Case Officer: Caroline Ford

Recommendation: Approval

Applicant: London and Regional Properties

Proposal: Foul water tank and pumping station compound and enclosure to serve approved hotel

Drawn	WB	TITLE	SALES DRAWING FOR EUROGUARD PLATFORM MEDIUM FENCING 1.83m HIGH	
Date	06/12/10		CUSTOMER	Drawing No.
Checked		ACK No.		Sheet 3 of 5
Size	A3	Scale	1:16 U.O.S

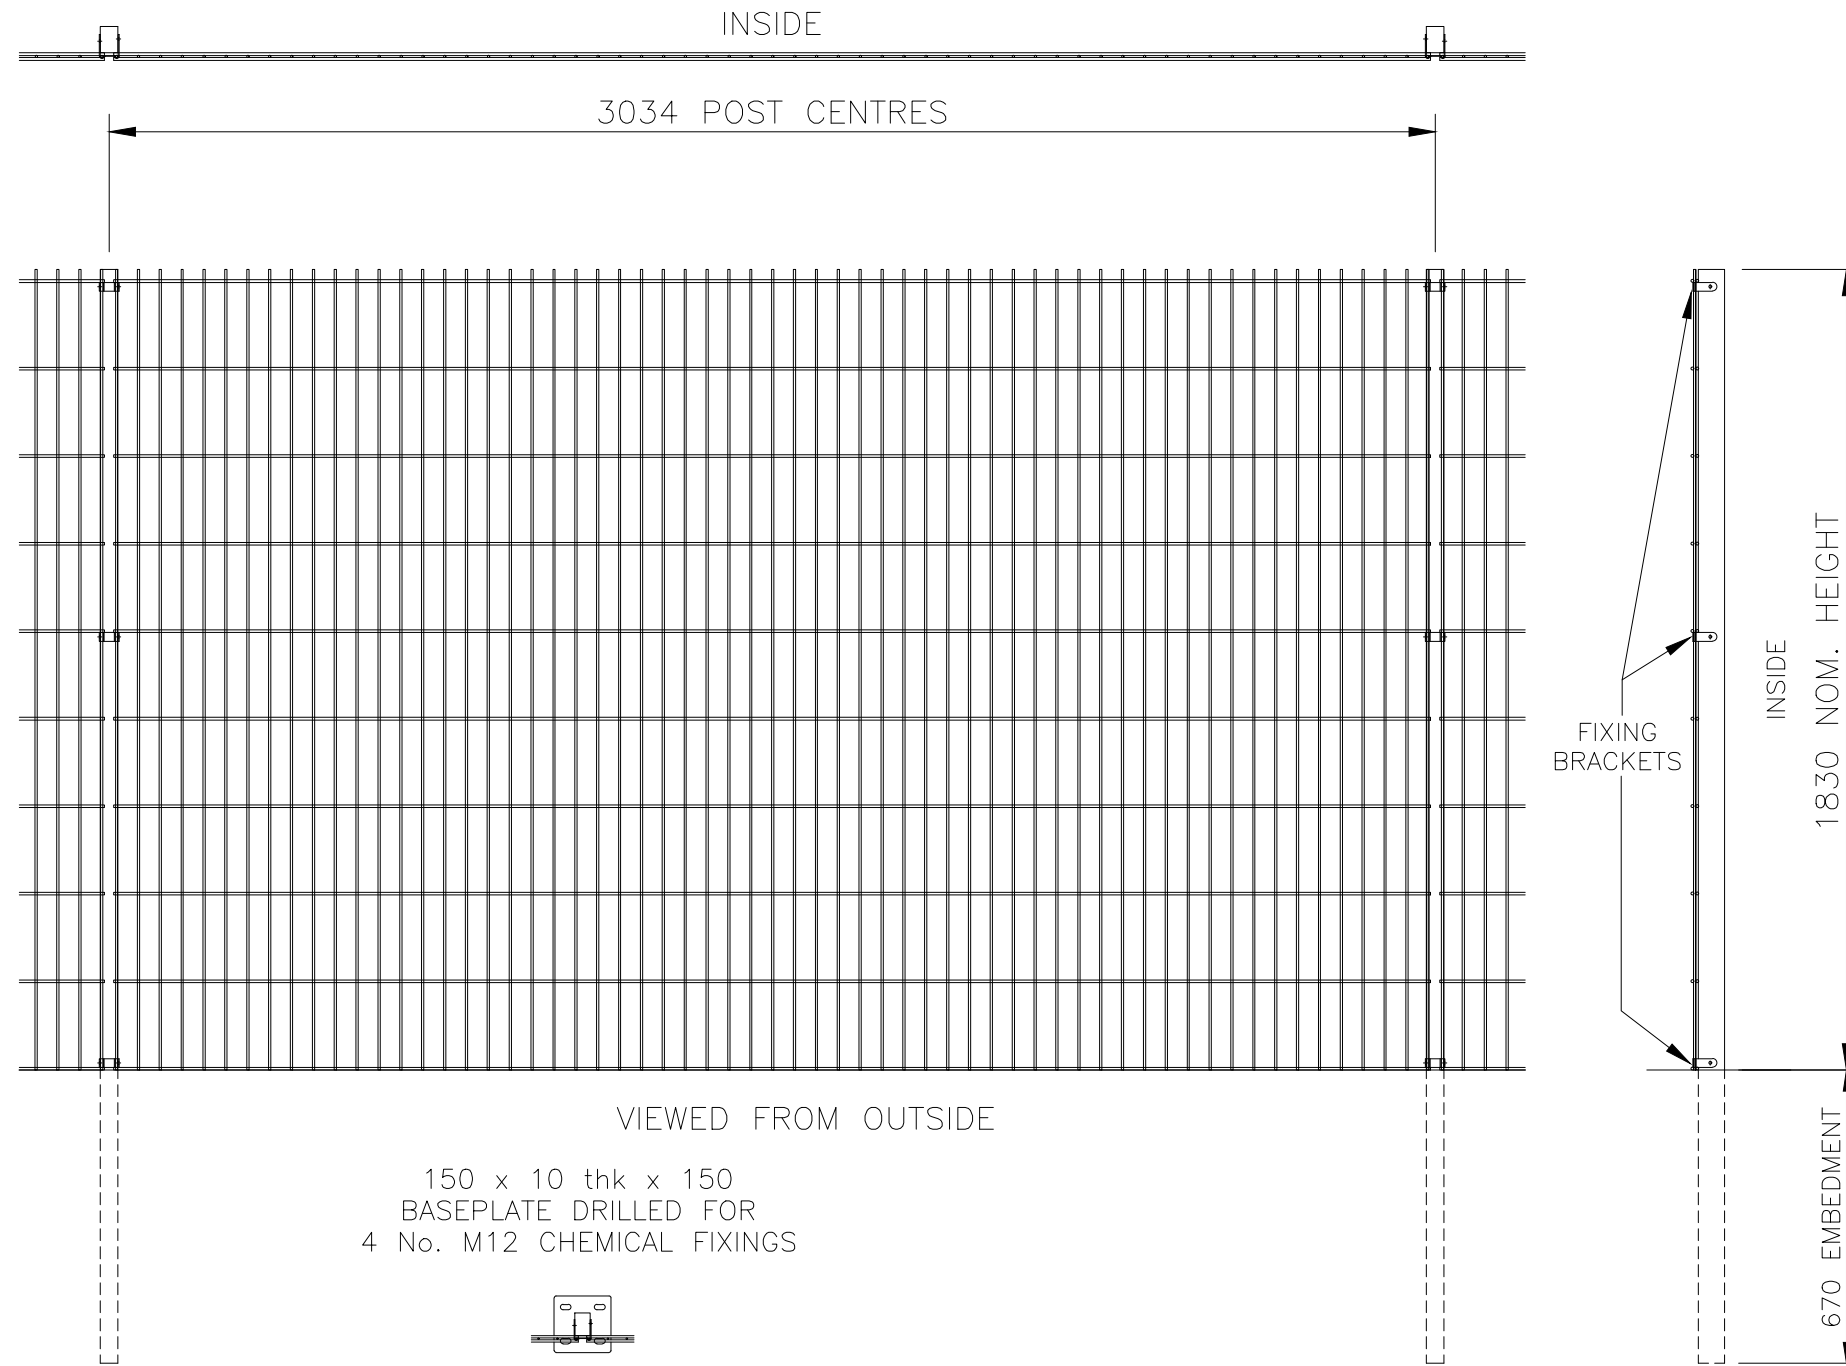
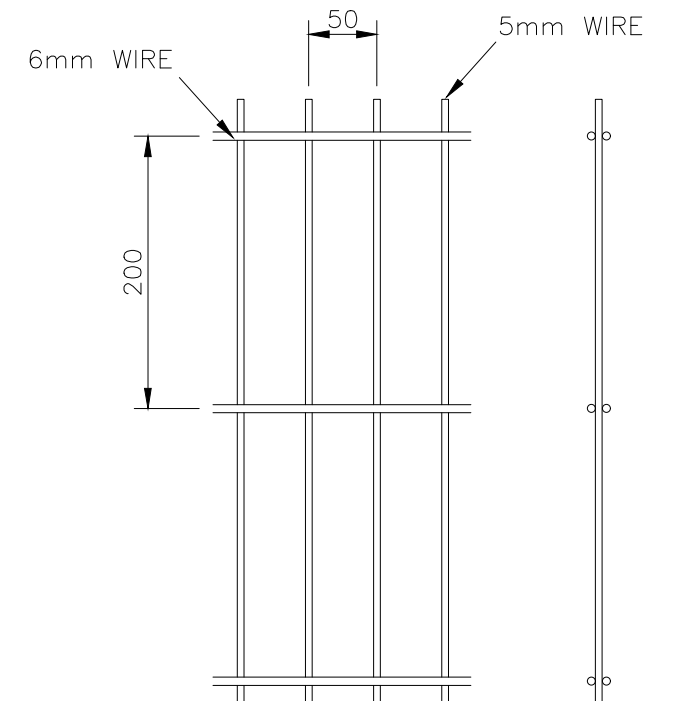
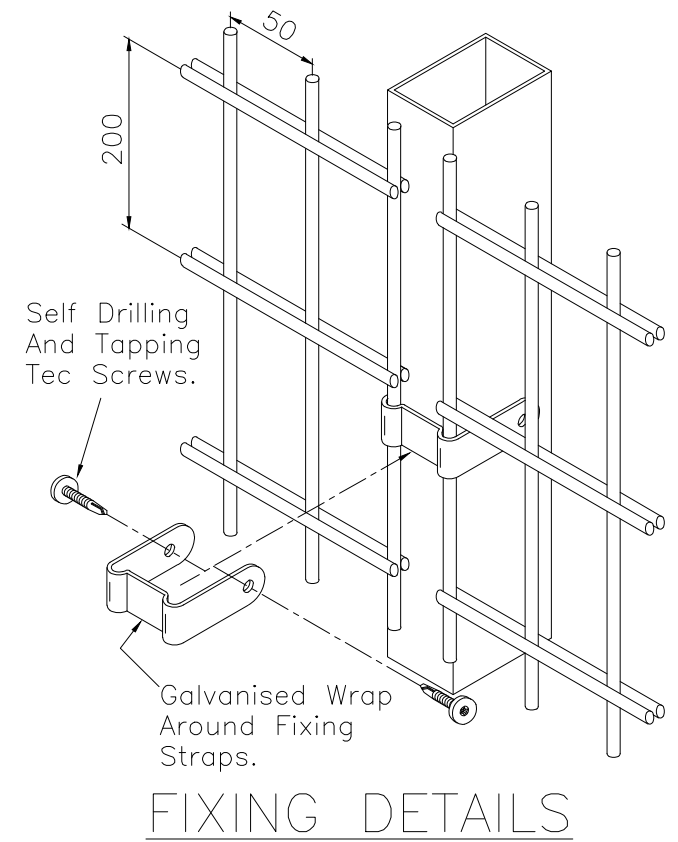
- Is the existing foul drainage system inadequate to cope with the hotel?
- Are measures in place to deal with food residues, cleaning detergents and any noxious emissions?
- Is the weldmesh fencing adequate for the pumping station in its current location close to traffic flows and potential mis-judgments?
- There is a recognition that this is a necessary provision for the hotel.
